# Rezoning Transportation Analysis

Petition Number: 2021-186

Date	Description
12-28-21	First Review (TNM)
01-27-22	Second Review (PDM)

REZONING - SITE PLAN
THE VILLAGES AT GOVERNOR HUNT
 9405 MALLARD CREEK RD., CHARLOTTE, NC

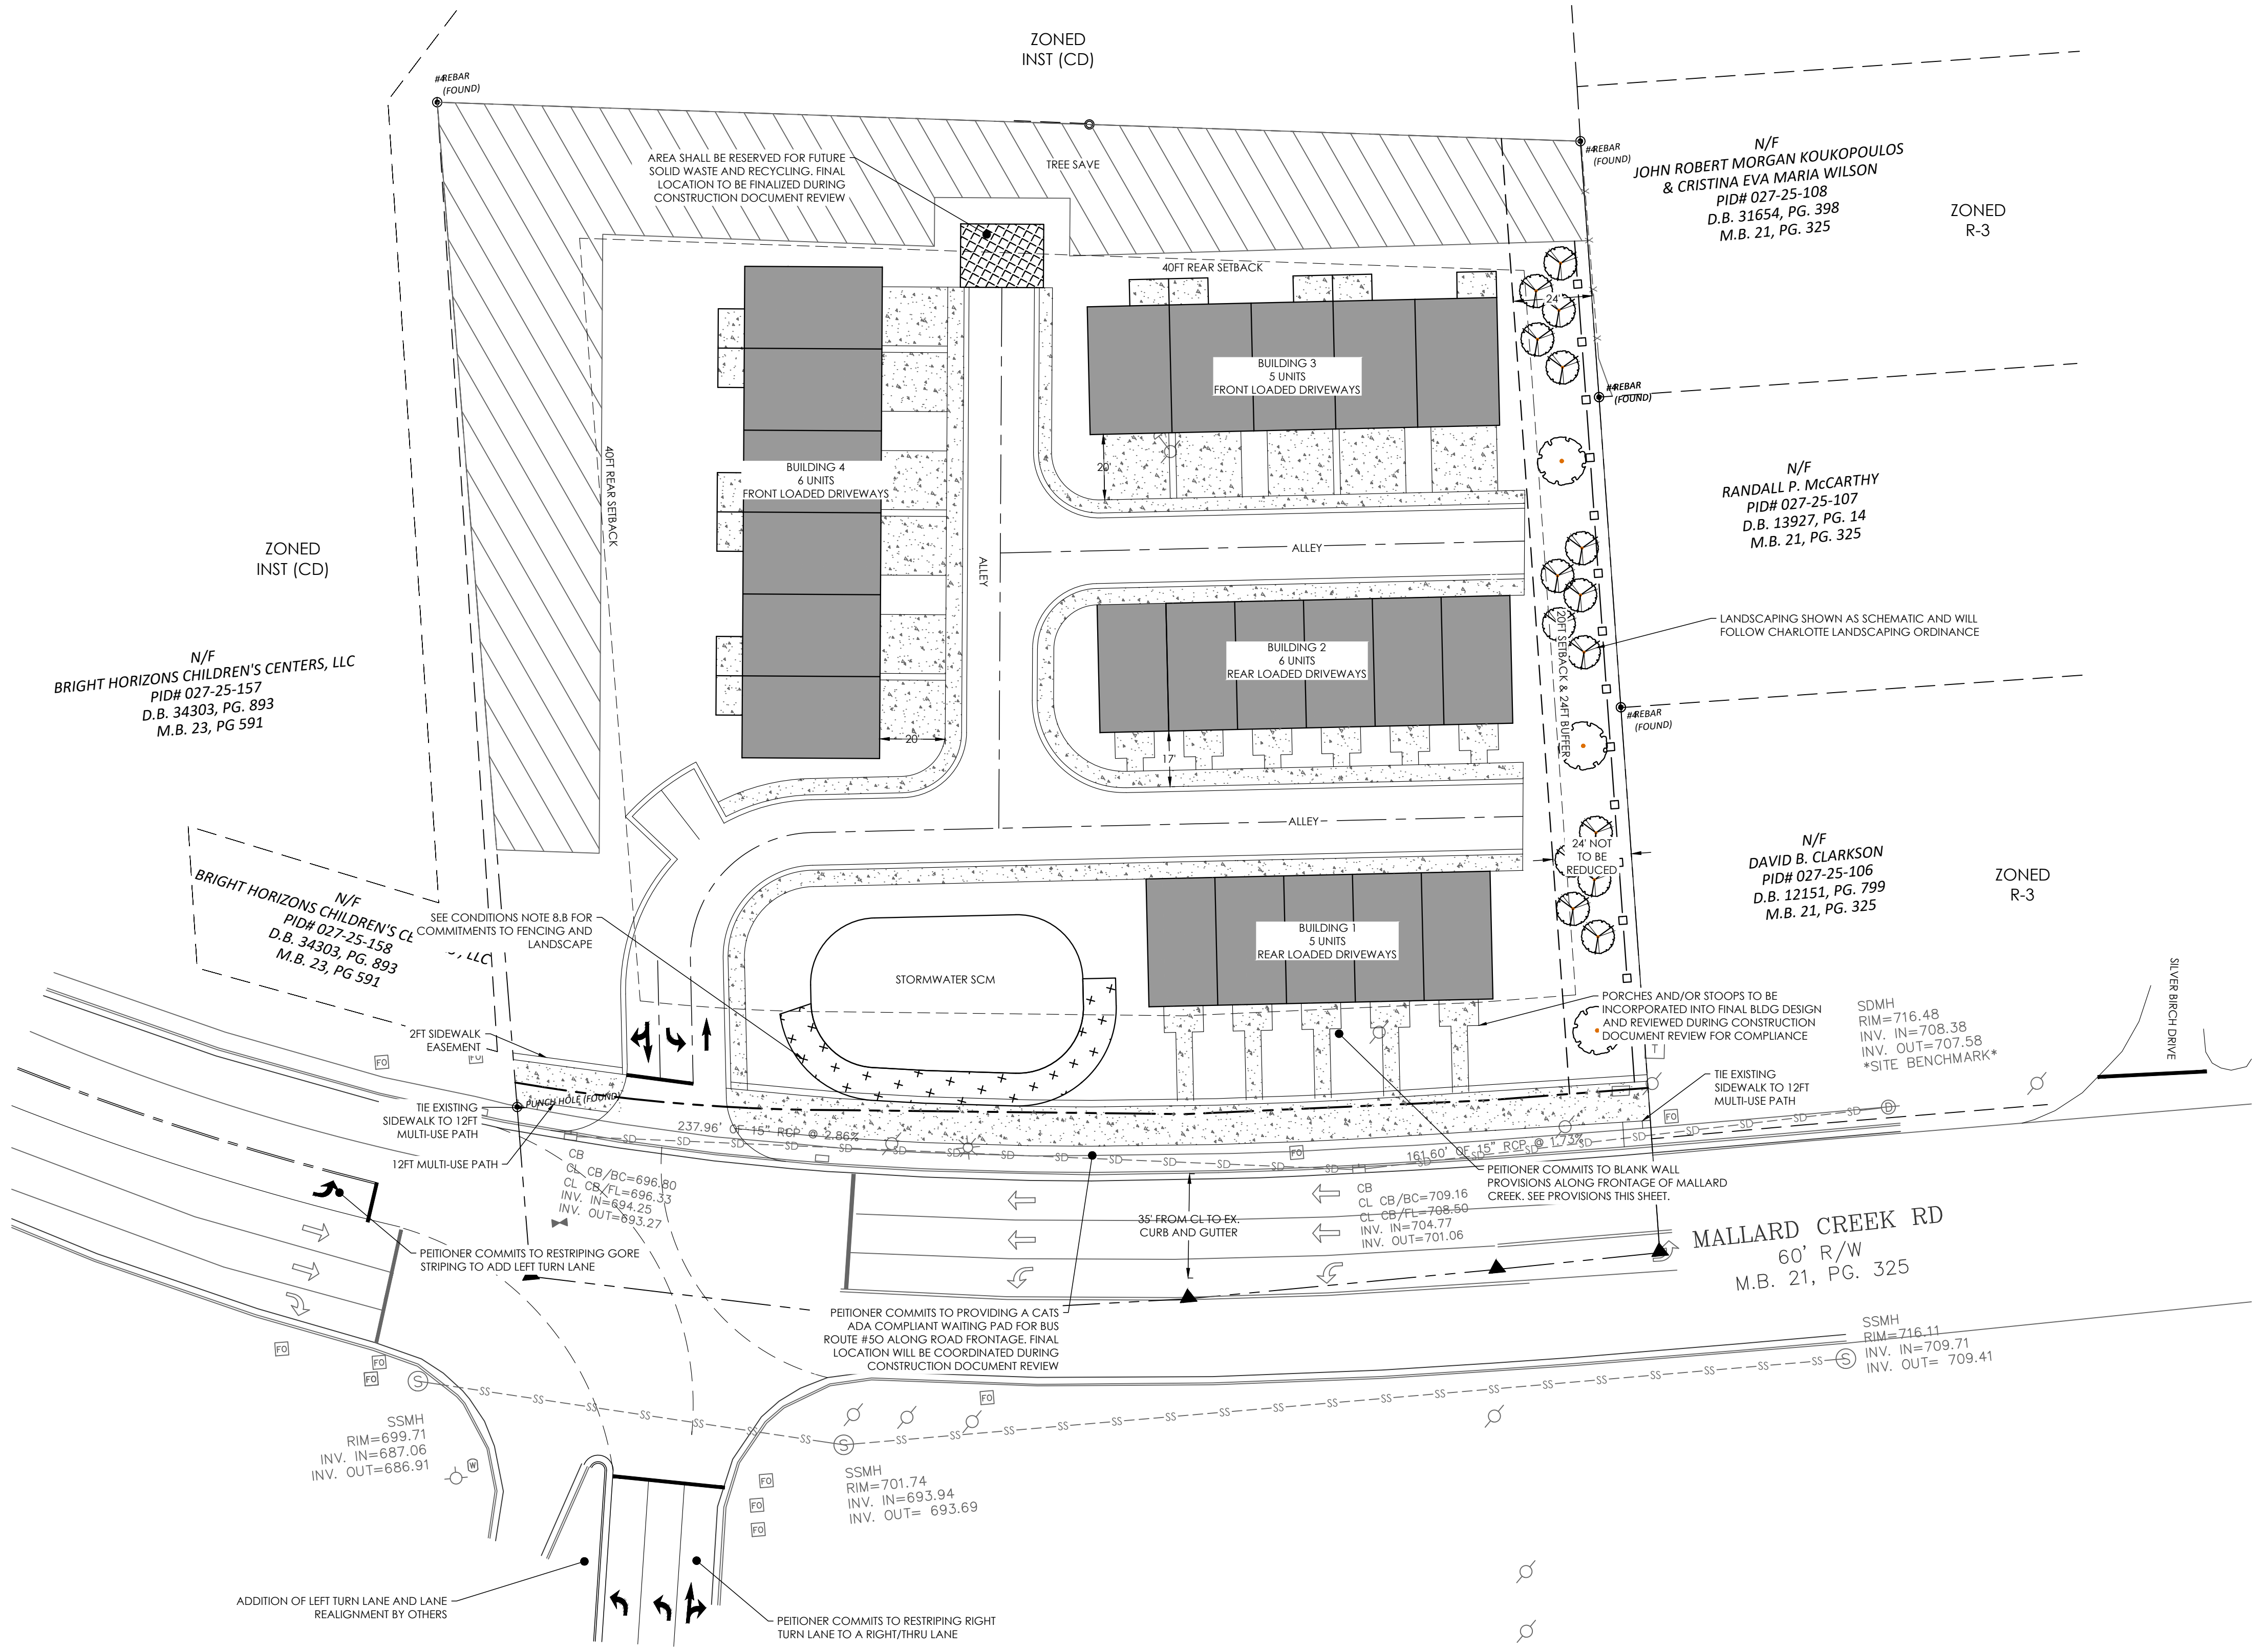
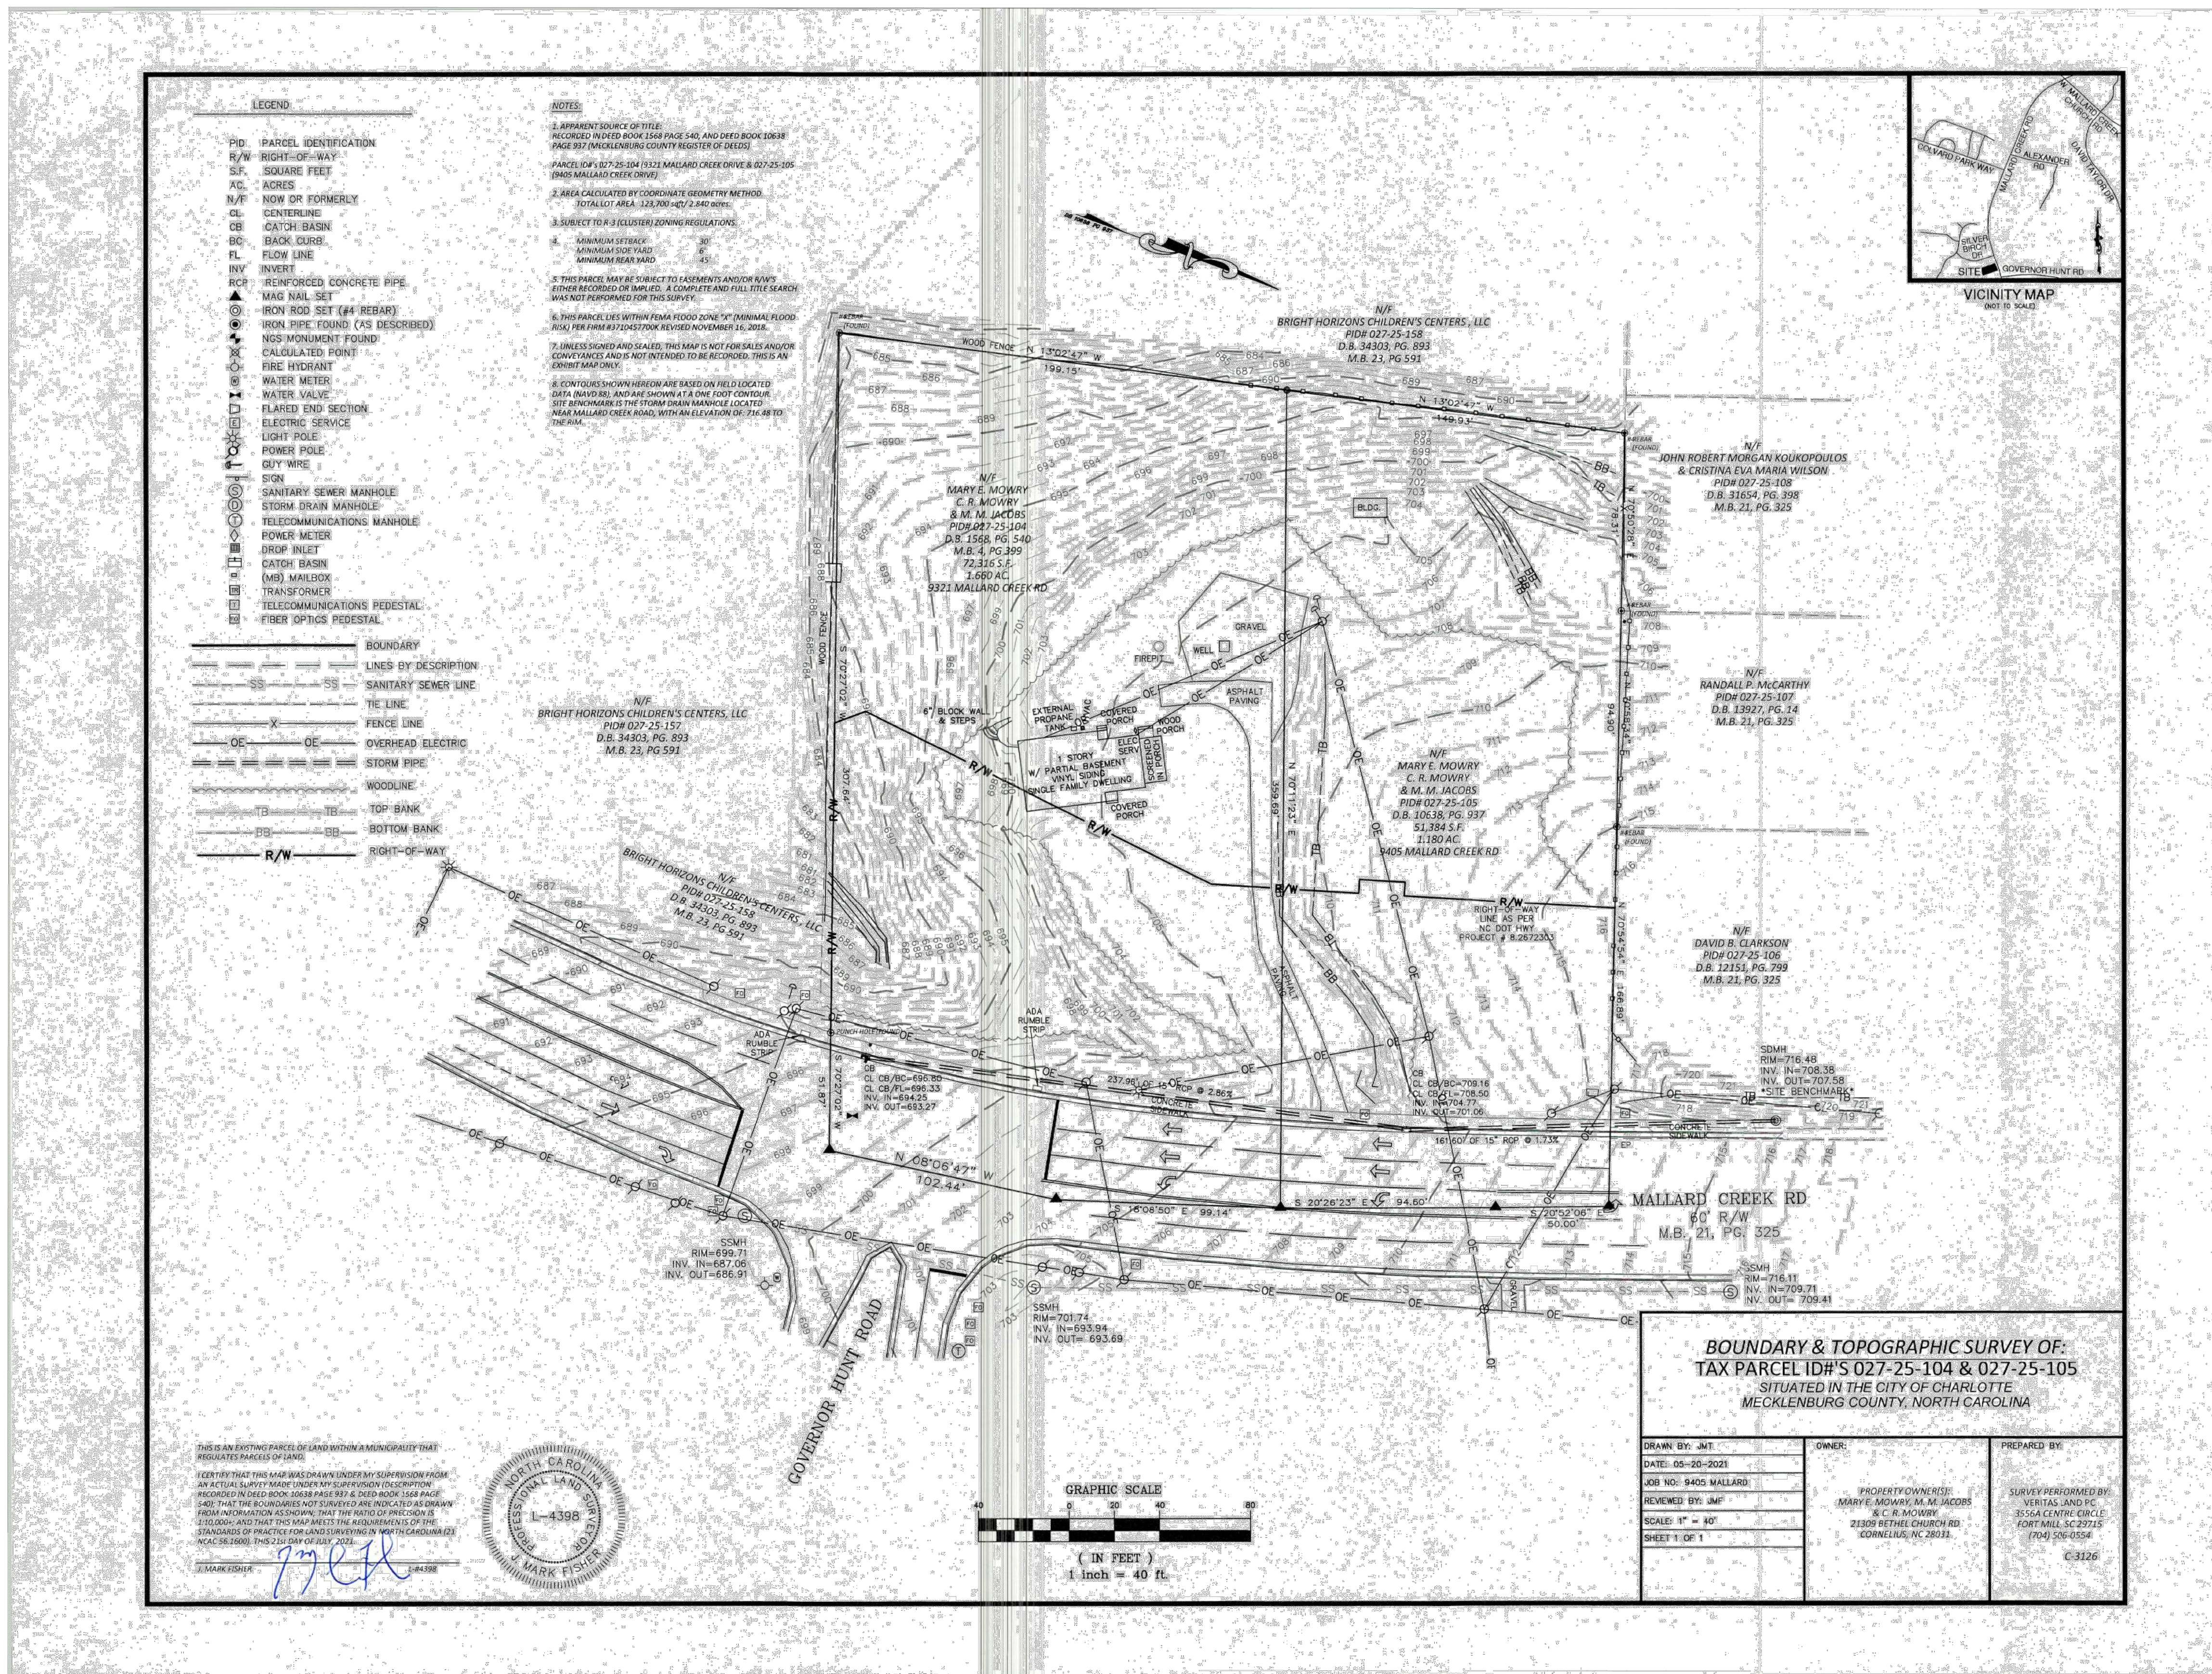
**Outstanding Comment from 01.27.2022:** Label and dimension the curb and gutter from the centerline for each road on the site plan.

**Clarifying Comment from 01.27.2022:** Median needs to be designed to allow for a minimum of 150ft of full width storage for the Mallard Creek left turn lane at Governor Hunt. Show 150ft of full width (11ft) storage. A conditional note specifying the requirement of the 150ft of full width storage and the concrete median should be added to provide clarification.

- Revise site plan to show the driveway radius tie into the existing curb and gutter at a tangent and ensure the driveway radius tie in point remains on the property.

**Clarifying Comment from 01.27.2022:** Driveway radius needs to tie into the curb line at a tangent.

- 12. NEW Comment from 01.27.2022:** Proposed 12-ft multi-use path along Mallard Creek Rd should extend the entire property frontage per Ch 19. SUE is required 2ft behind multi-use path if located outside of the 50ft dedicated ROW for future maintenance.
